Address: Primrose Barn, 272-274, Crossley Lane, Mirfield, WF14 0NR

Application number: 2025/93355	
What is the application for?:	Erection of 75 residential dwellings with associated landscaping, open space, hi
Address of the site or building:	Land off, Woodward Court, Mirfield, WF14 0PY
Postcode:	LS15 8ZB

Type of comment: An objection	
Do you wish your comments to be published on the website anonymously?	No

EXISTING 30MPH SPEED LIMIT ON HEPWORTH LANE BUT SEE NOTE 2 FOR ACTUAL SPEEDS

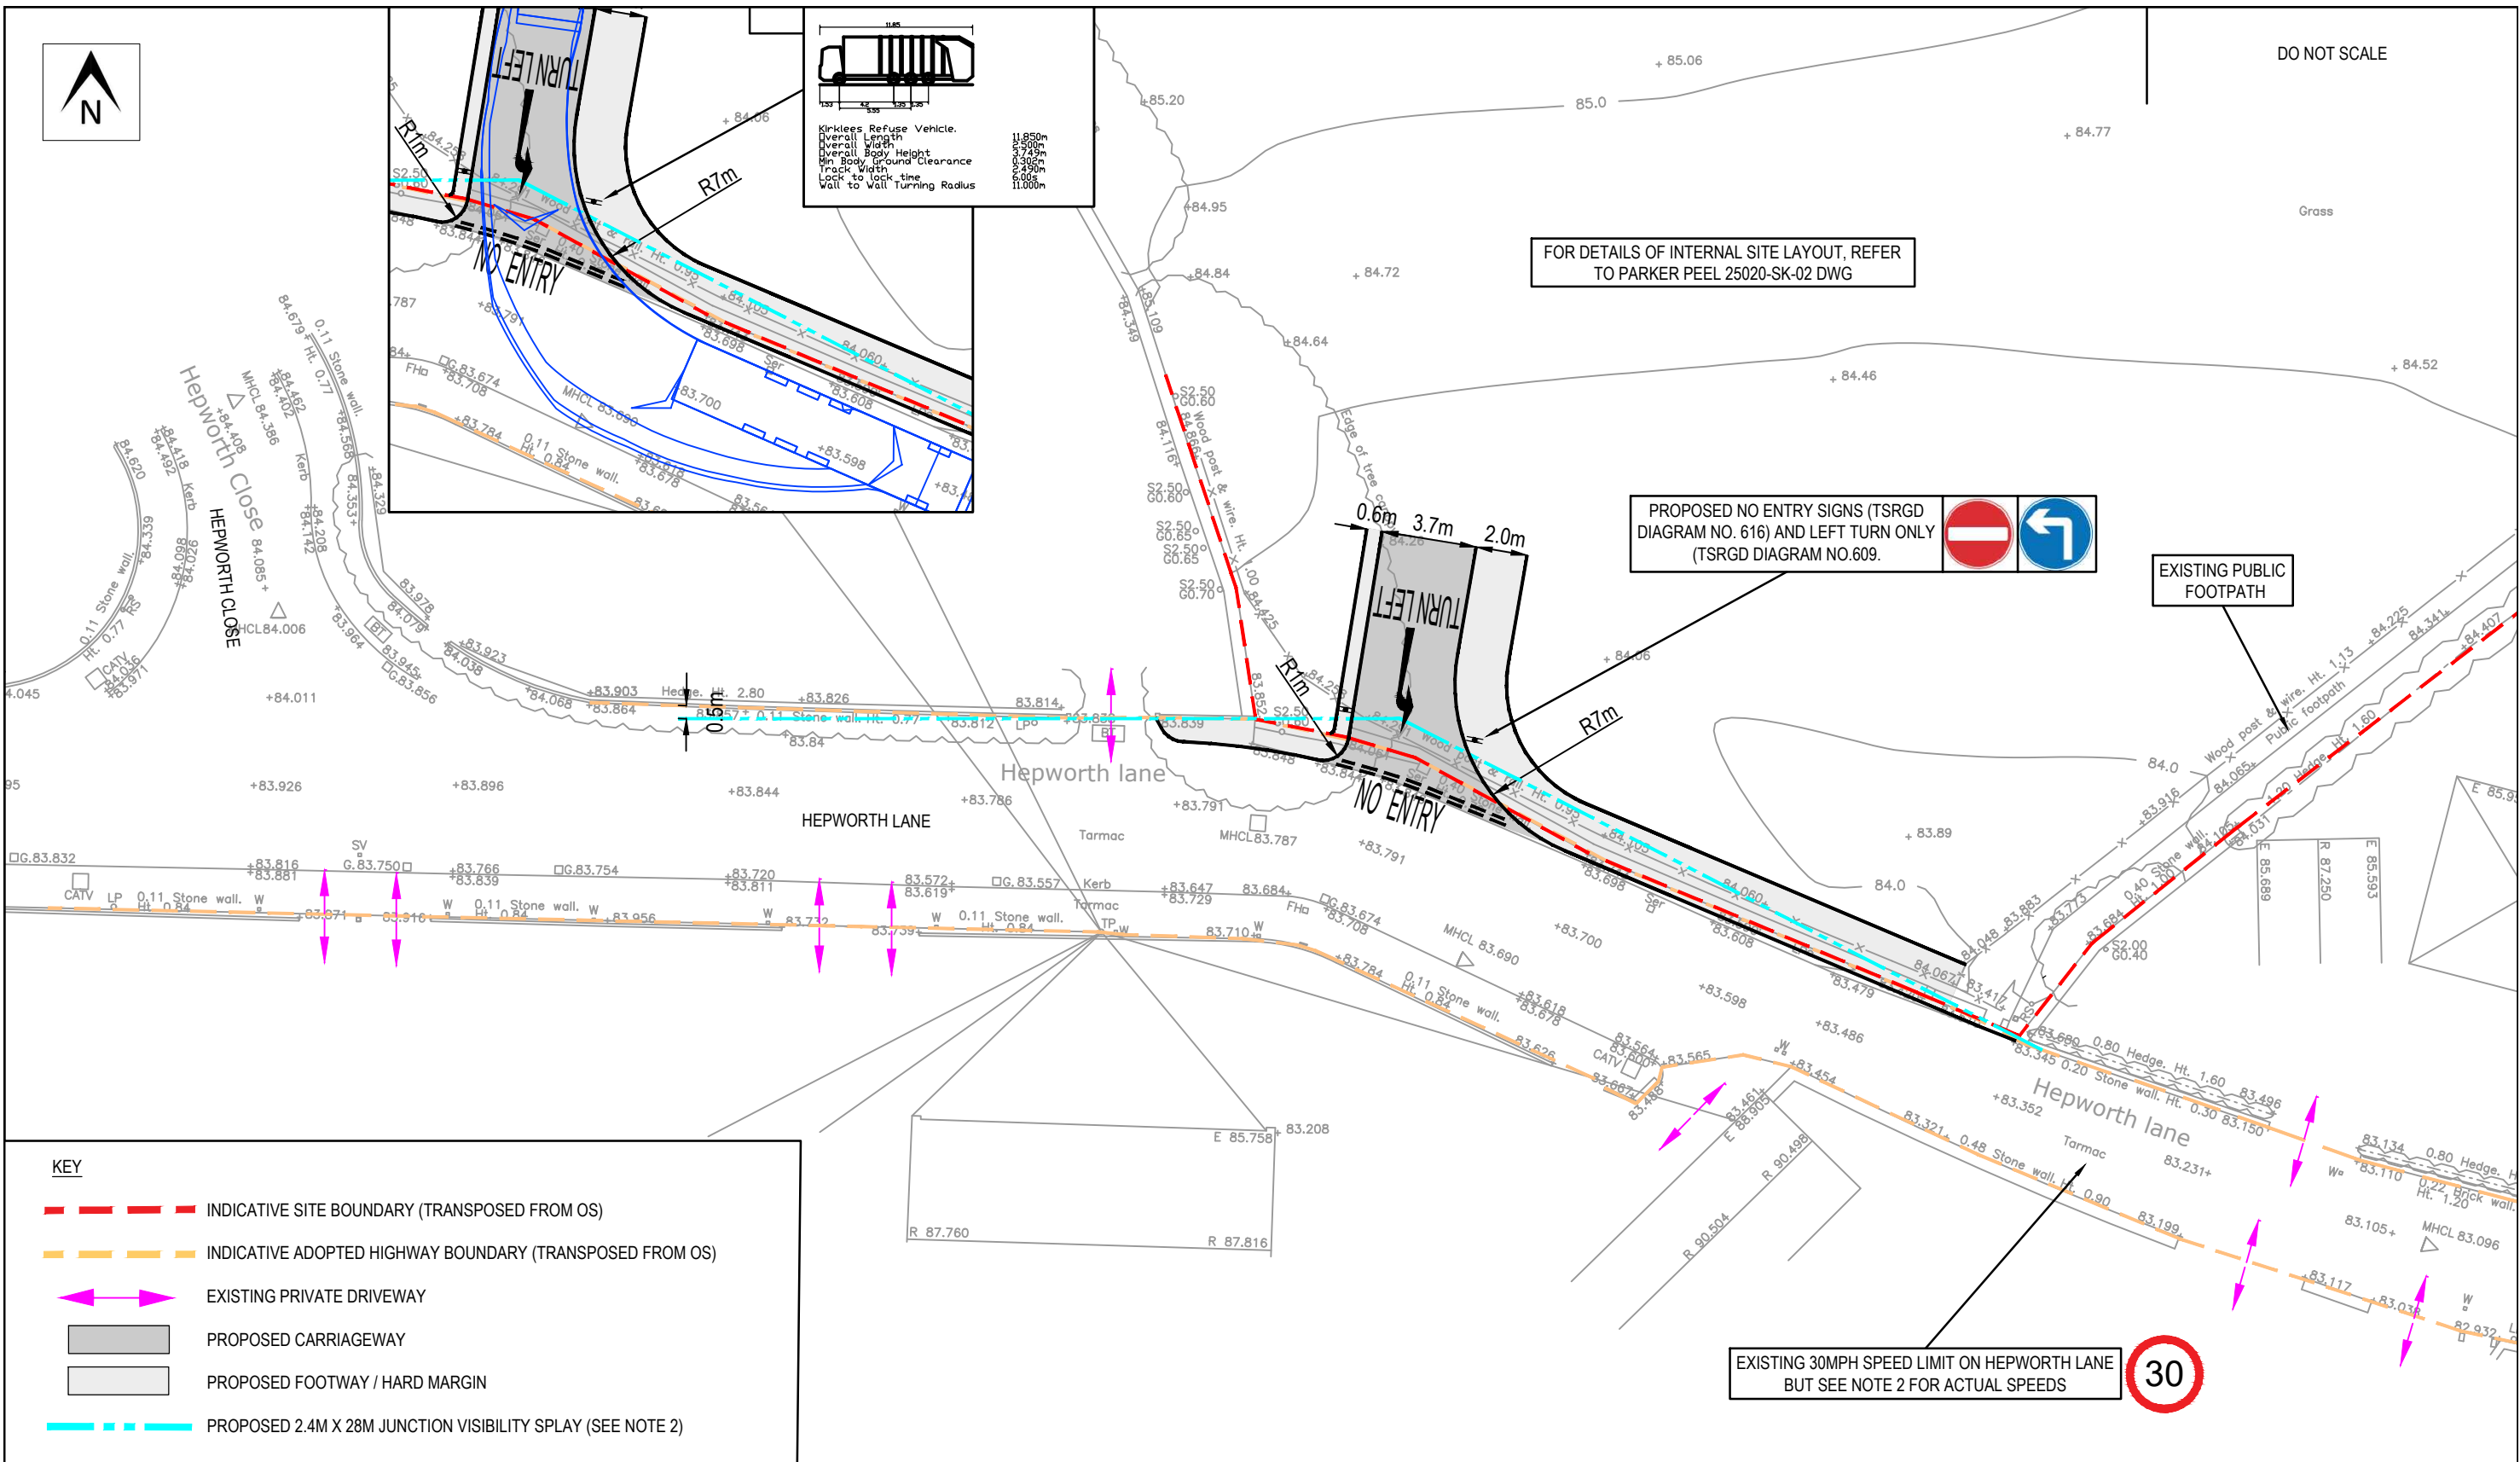
The proposed "exit only" arrangement onto Hepworth Lane is equally unsafe. Hepworth Lane is extremely narrow, lacks pavements, and has limited visibility; vehicles and pedestrians cannot pass comfortably or safely. An exit only restriction is unenforceable and likely to be ignored, as evidenced by the routinely ignored one way section from Hepworth Lane to Wellhouse Lane. Previous applications were refused on highway grounds for lower densities. No improvements have been made to the road network since those decisions, yet this application increases the density from 61 to 75 dwellings, intensifying known problems.
